**Homestead at Sterling Ranch Filing No. 2A, and Sterling Ranch, Filing 1A,  
VR-23-4**

**Please accept the following comments from El Paso County Public Health regarding the vacation/replat project referenced above:**

Pond 1 - Tract B1, Homestead at Sterling Ranch Filing No. 2A and Sterling Ranch Filing No.

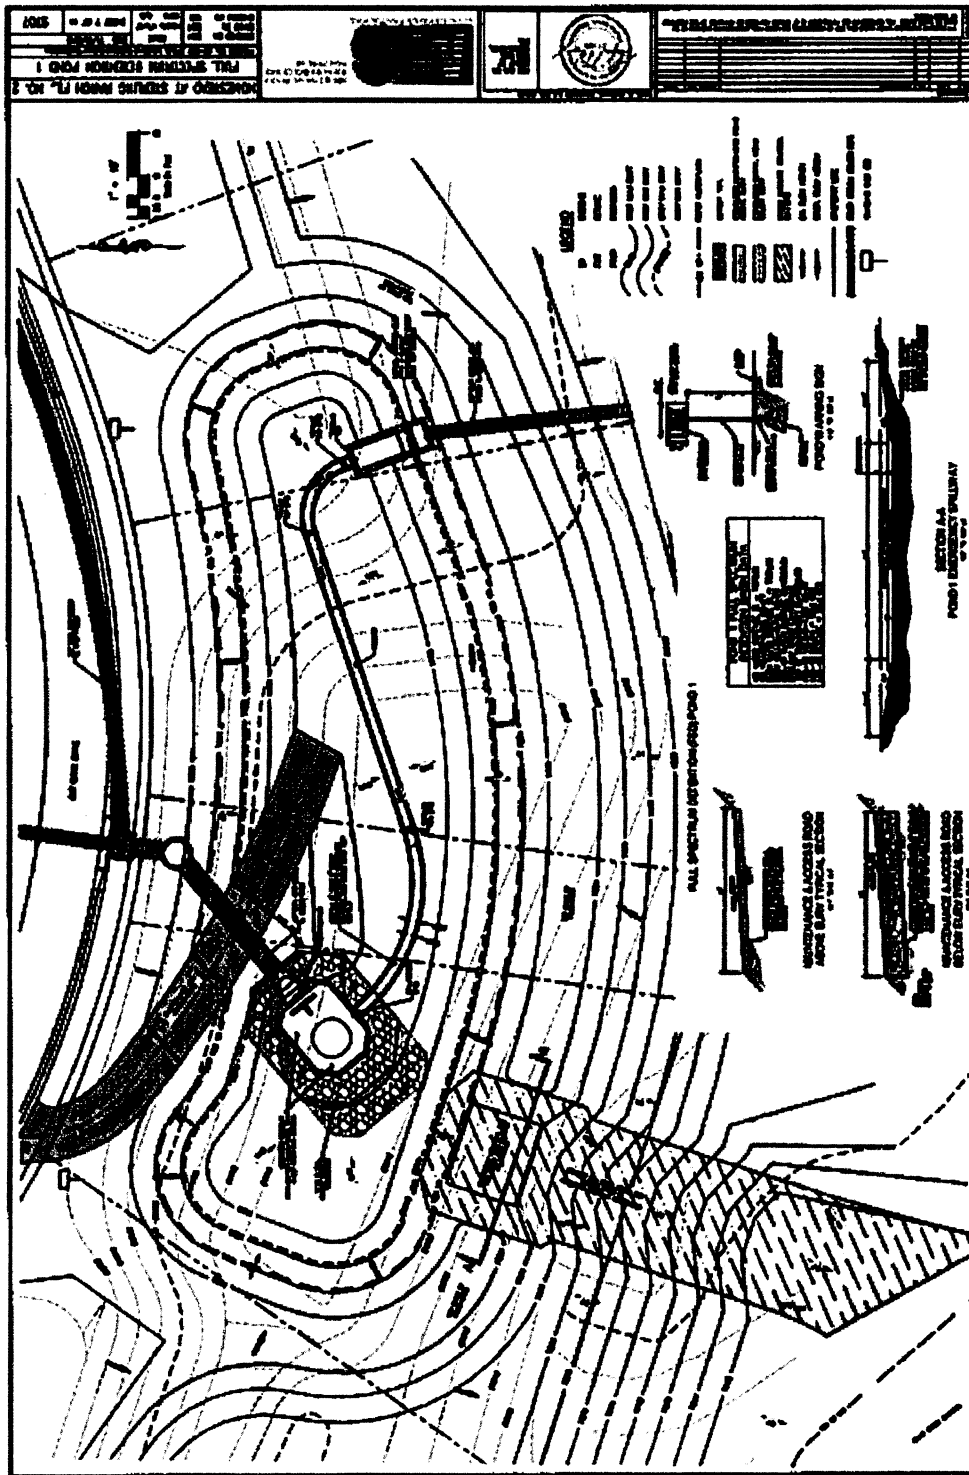
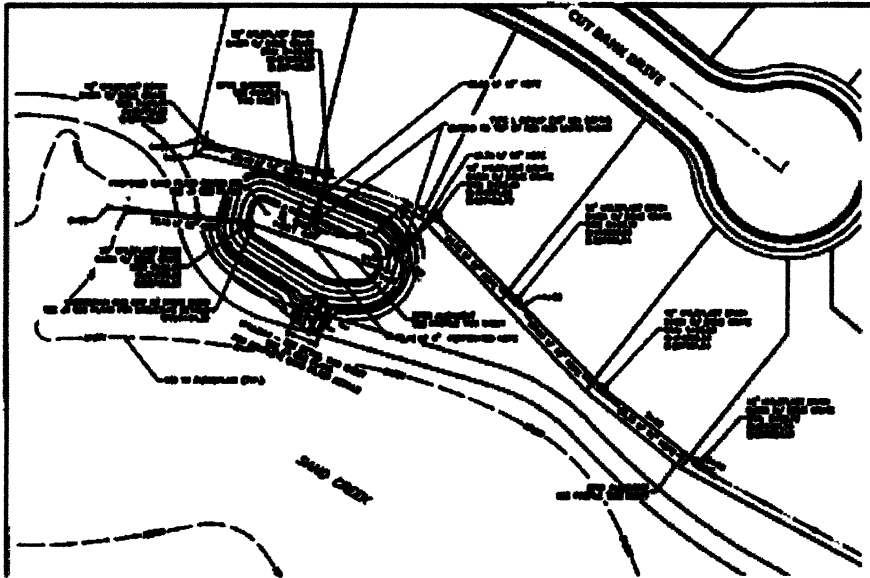
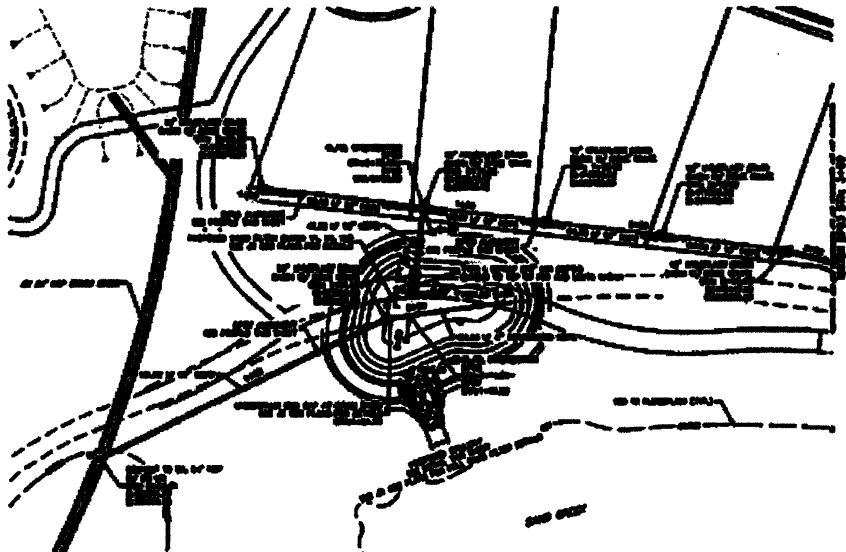
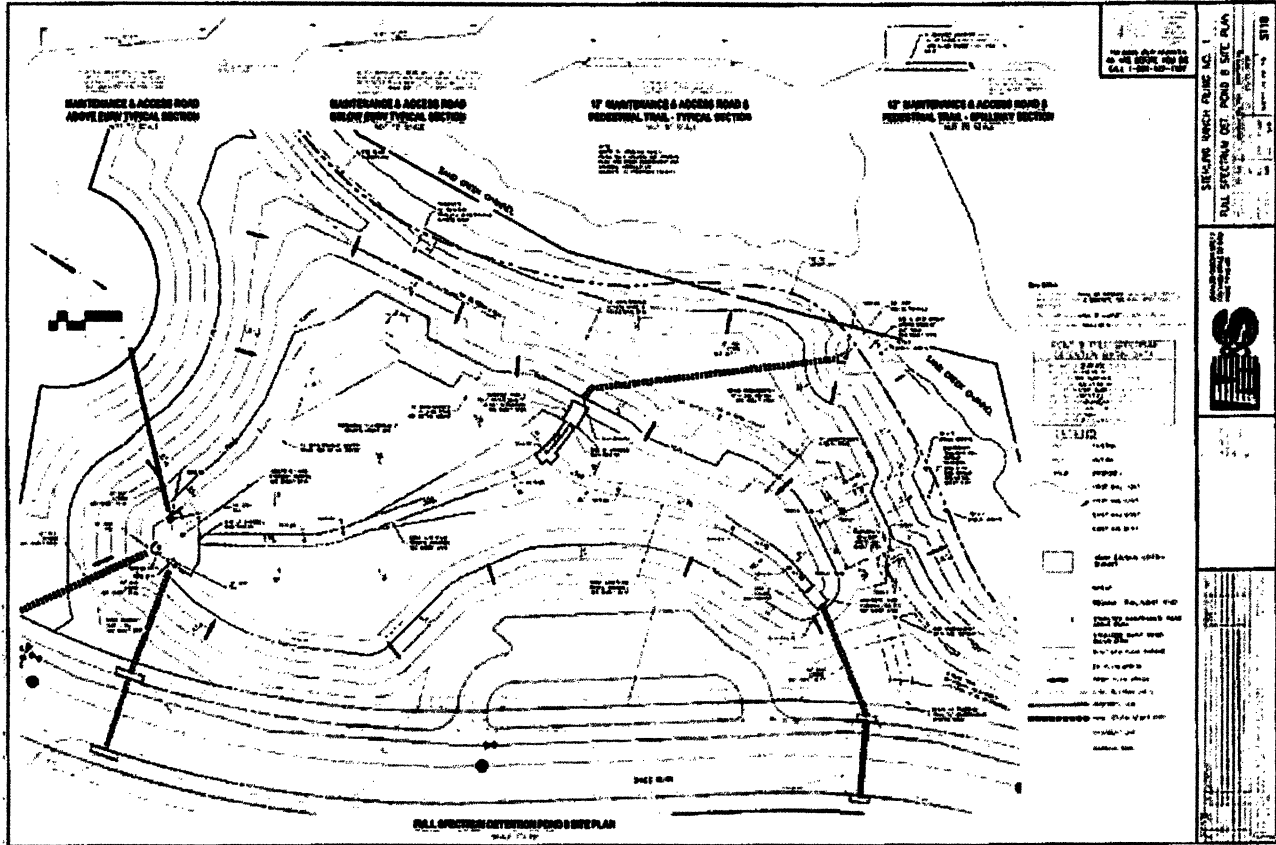
- **The water quality basin must have mosquito control responsibilities included as a part of the construction design and maintenance plan to help control mosquito breeding habitat and minimize the potential for West Nile Virus.**
